# Rezoning Transportation Analysis

Petition Number: 2023-016

## Revision Log:

Date	Description
6-28-23	First Review (PDM)

SHEET NUMBER
RZ-1.0

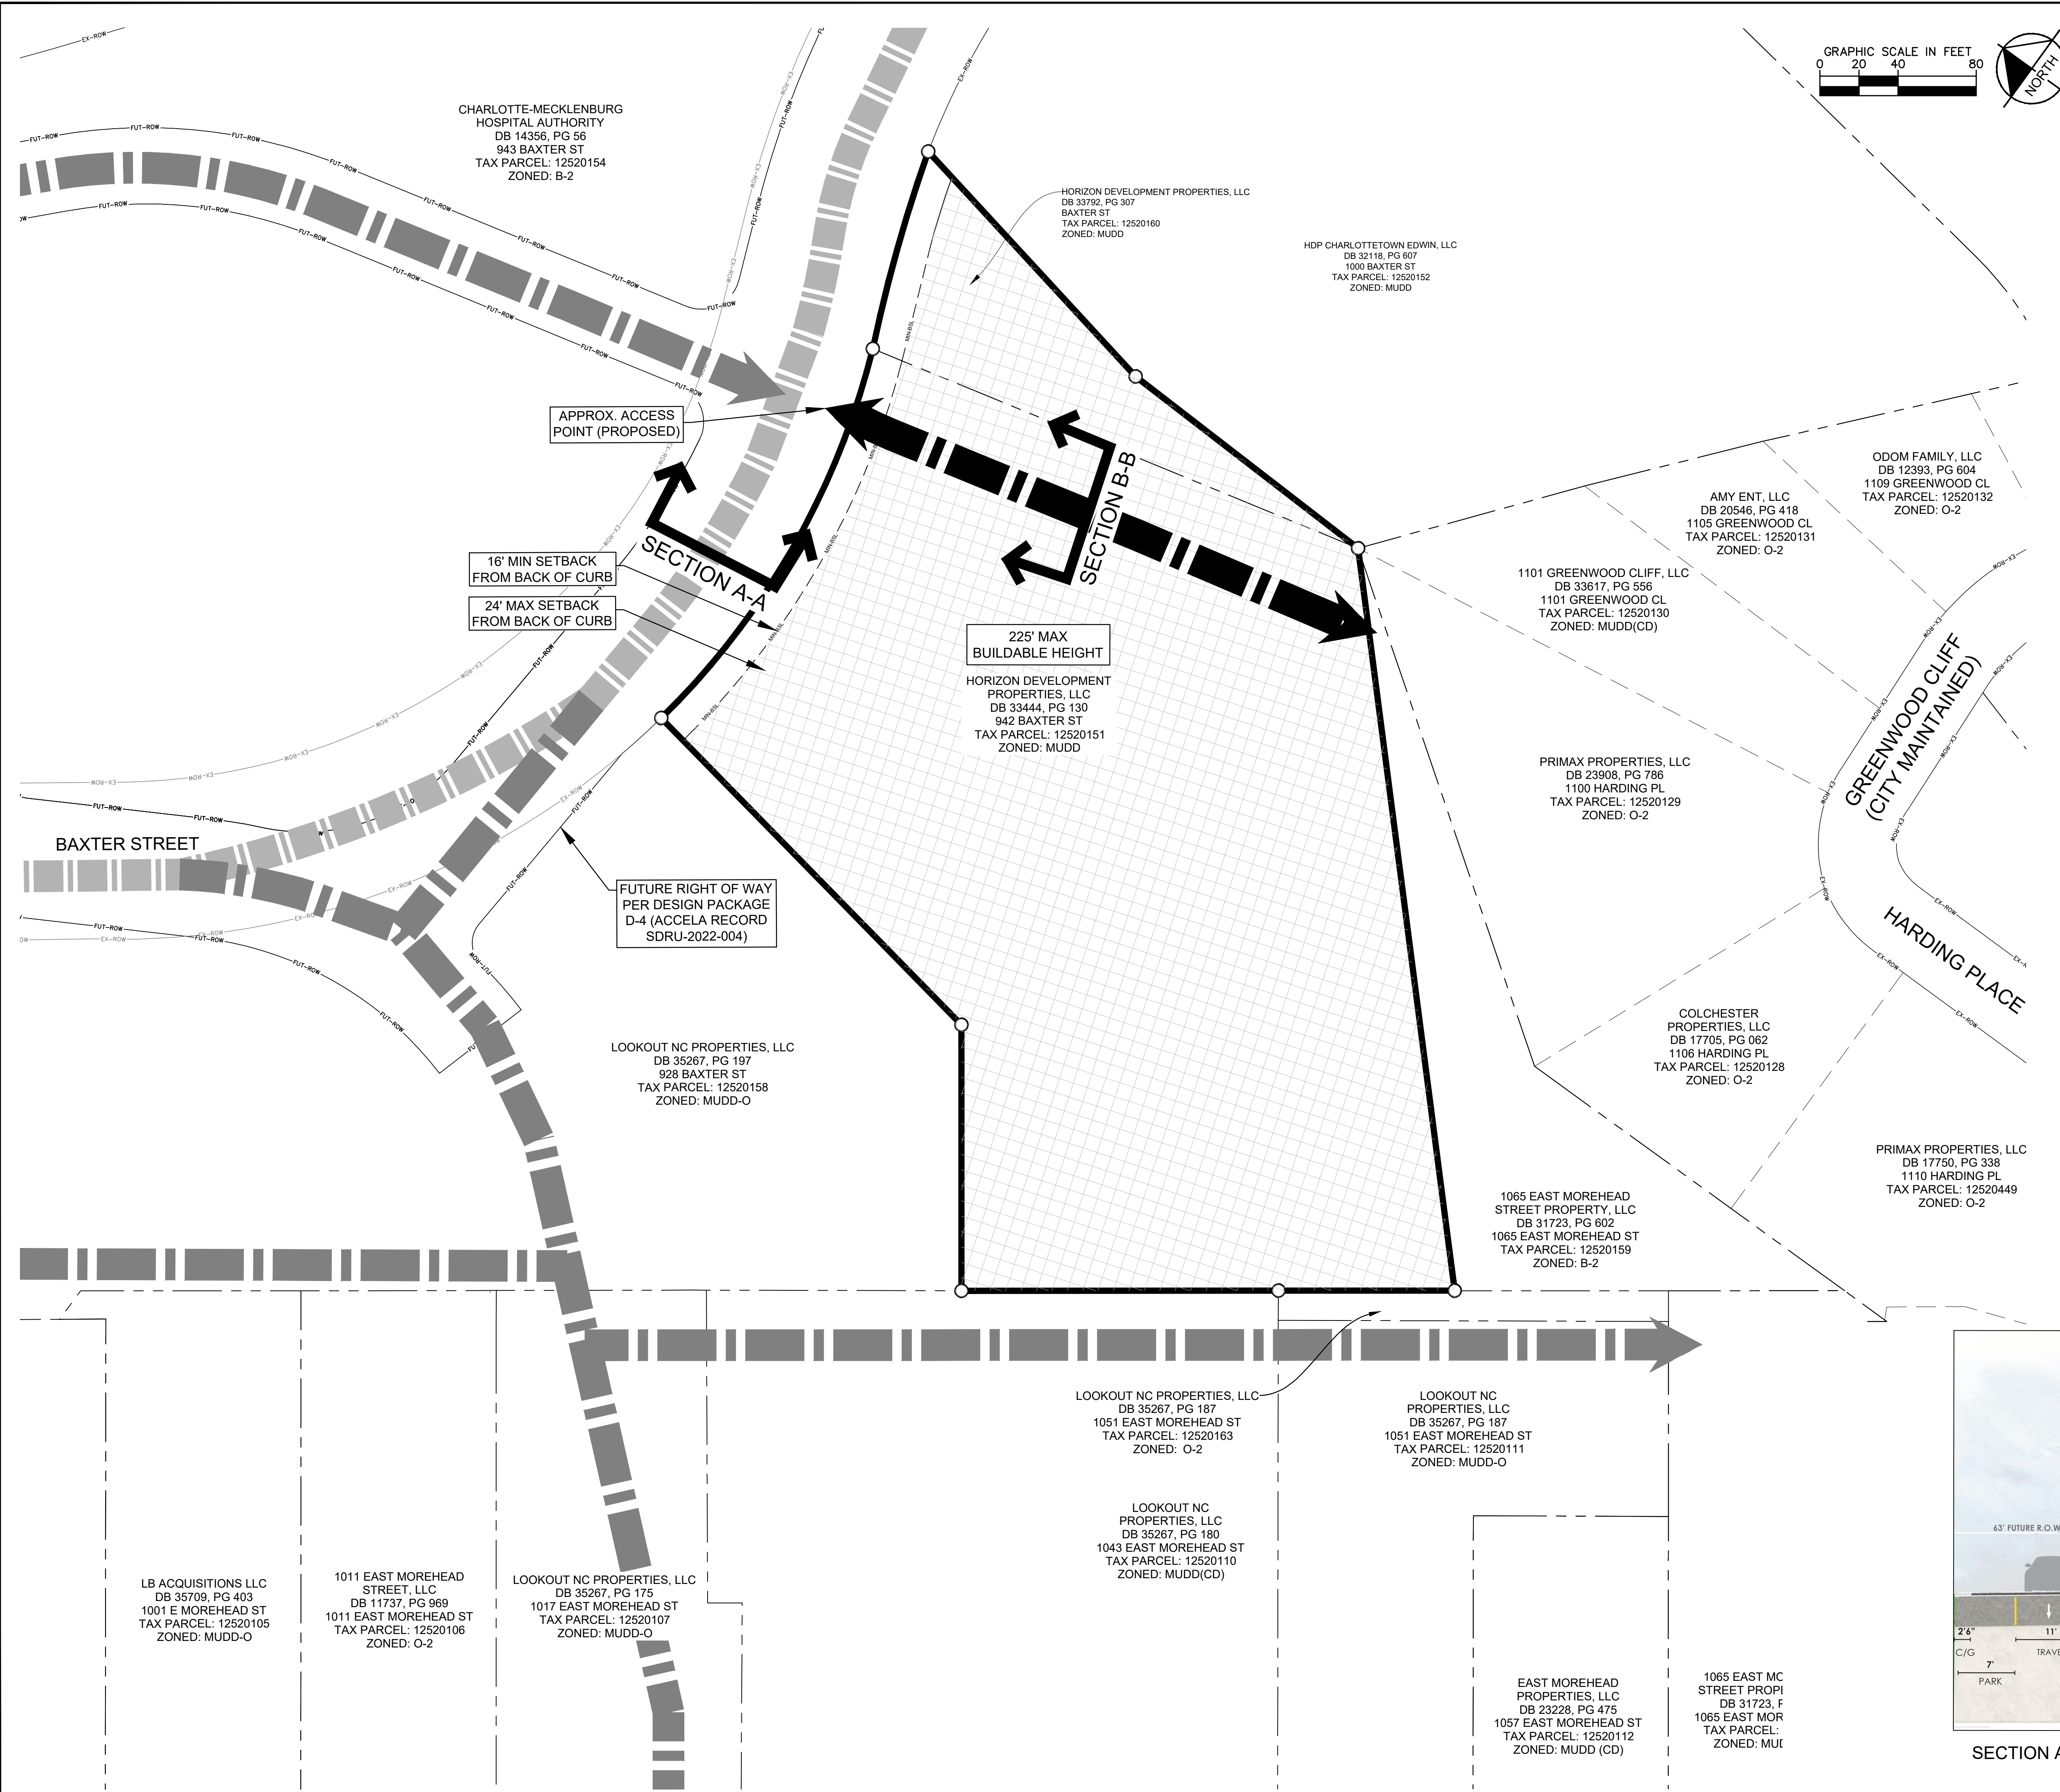
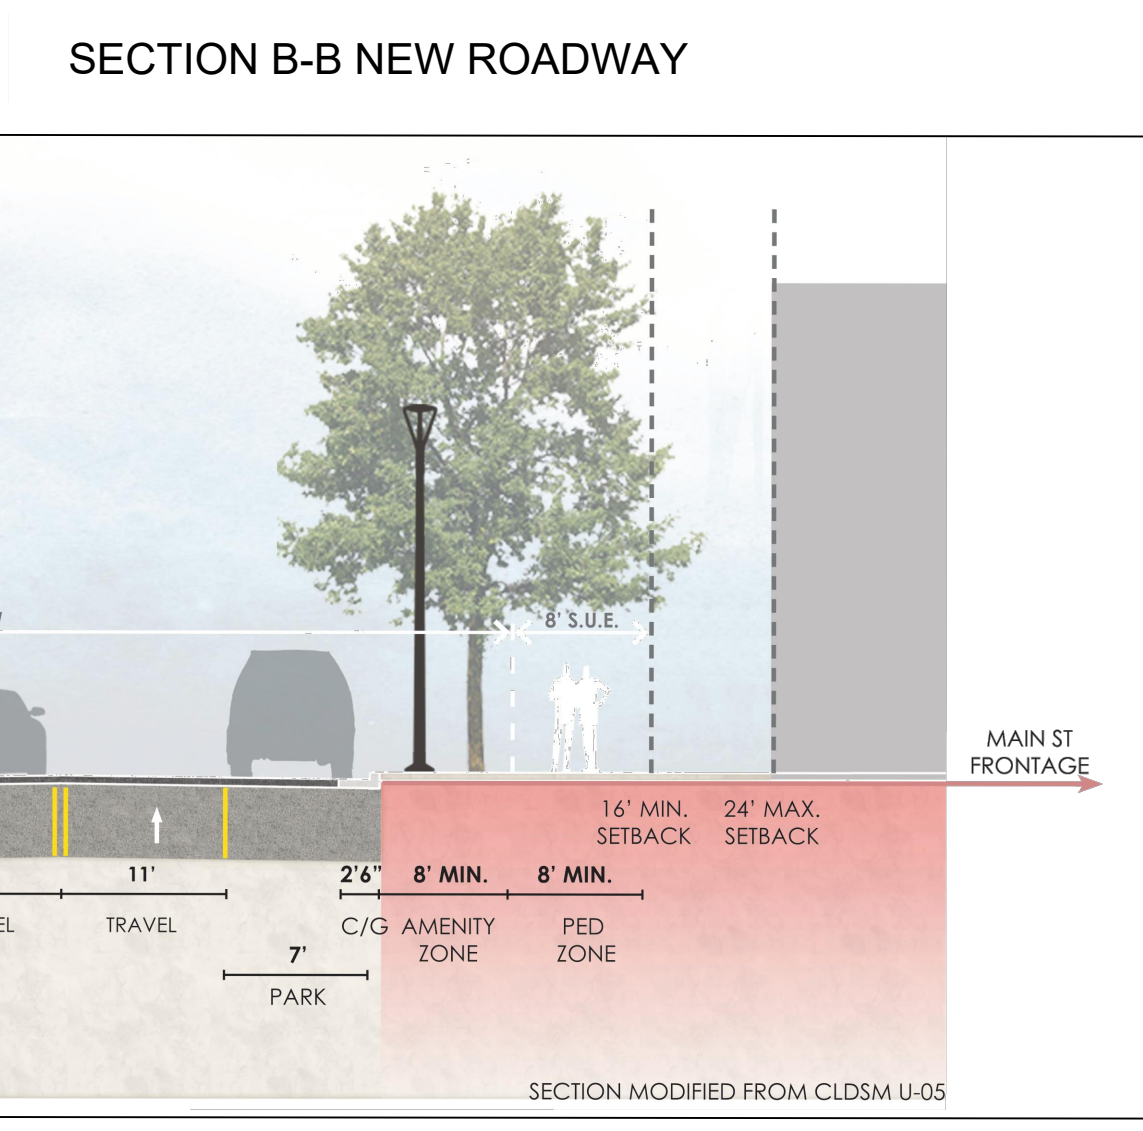
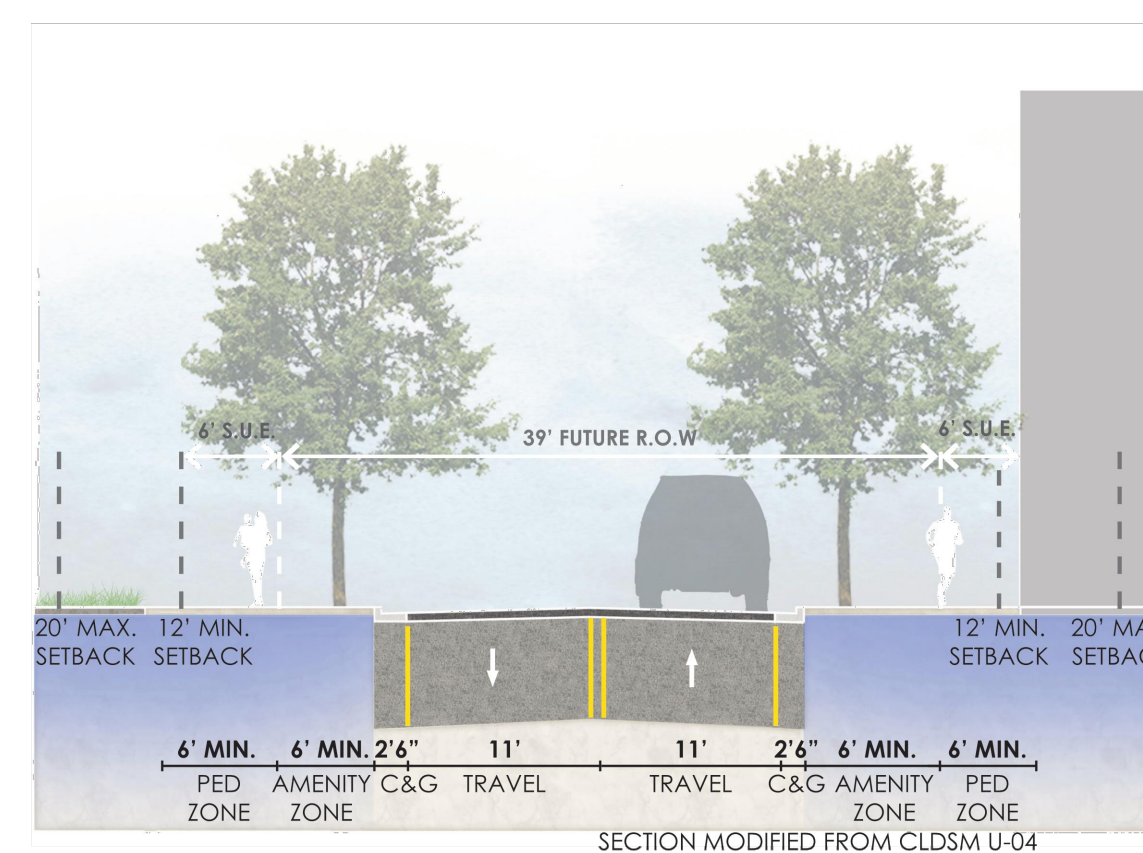
2. Revise site plan and conditional note(s) label and dimension all public rights-of-way and future back of curblines from the centerline of the road.
3. Revise site plan and conditional note(s) to clarify the proposed street(s) as public or private. In addition label each street with the applicable road name. There are discrepancies between Peal Park Way and Baxter Street.
4. Revise site plan, conditional notes, and typical sections to commit to construct an 8-foot planting strip, and 8-foot sidewalk along all public road frontages. The wider sidewalk also meets the Charlotte WALKS Policy.
5. Add a conditional note specifying "A Right-of-Way Encroachment Agreement is required for the installation of any non-standard item(s) (irrigation systems, decorative concrete pavement, brick pavers, etc.) within a proposed/existing City-maintained street right-of-way by a private individual,
